Phone: (01772) 533855  
Fax:  
Email: david.allen@lancashire.gov.uk  
Your ref: CONRSPB/3/2014/0438  
Our ref: 03/14/0438/SHP/DRA  
Date: 07 July 2014

**Application 03/2014/0438 - Development of 106 residential units, including affordable housing, new vehicular and pedestrian accesses, landscape and public open space, Land at Chipping Lane, Longridge.  
Applicant Barratt Homes**

David Allen  
Strategic Highways Planning

Drawing:
Boundary Treatment Plan

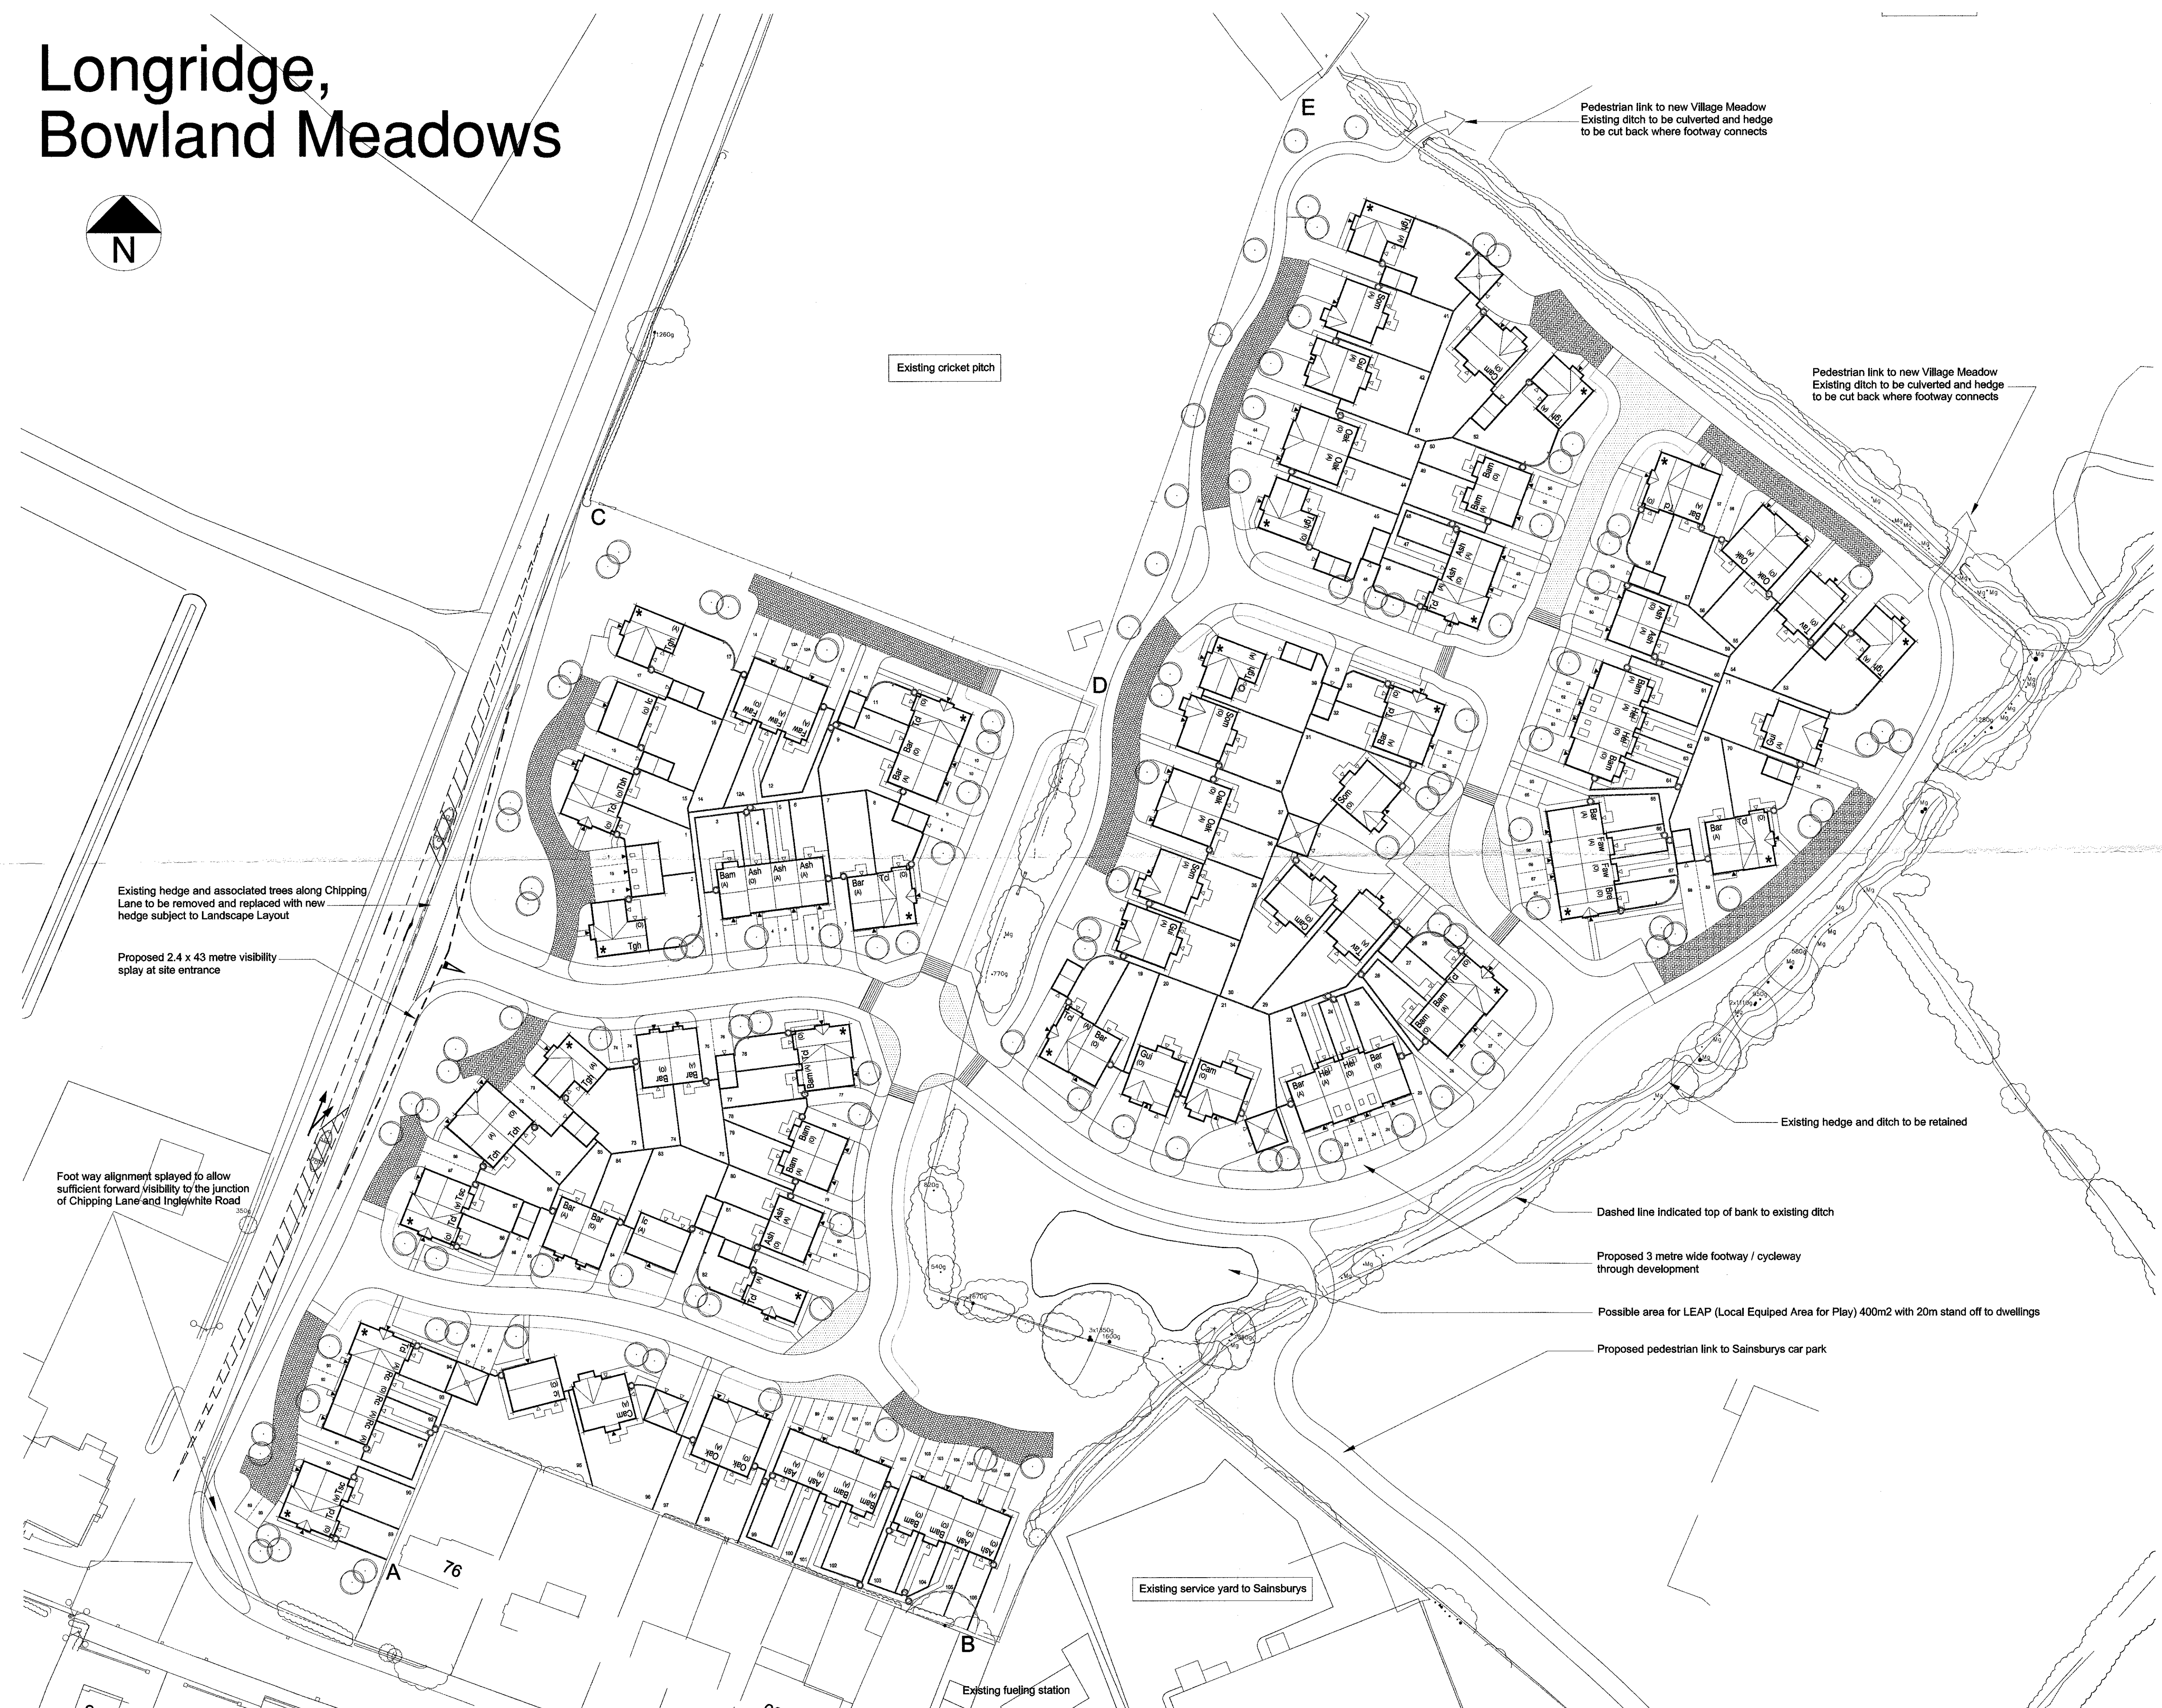
1. The access strategy provides an improved wider footway from the access southbound on Chipping Lane, but this should be 3m wide for shared pedestrian/cycle use to link to the internal pedestrian/cycleway running along the main site access road through the site.
2. It is proposed to extend the speed limit along Chipping Lane to the north of site, but no detail is included on the drawing. Details of the proposed change of speed limit must be supplied. Regarding the change of speed limit, I would anticipate a gateway treatment with a slight narrowing in the road together with new signs and lines, together with rumble strips.
3. With regard to visibility at the access; no speed readings have been submitted to support the proposed visibility splays. The evidence base for the proposed visibility splays must be submitted.

5. The TA also states a new footpath connection will also be provided which will link the site to the adjacent Sainsbury's site. This should maintain the 3m internal route with lighting. Is there agreement in principle to this provision from Sainsbury's? There may need to be internal work to the Sainsbury car park to provide a safe route through the store car park. Please confirm the arrangements with Sainsbury's. This connection must be delivered with the first phase of development.
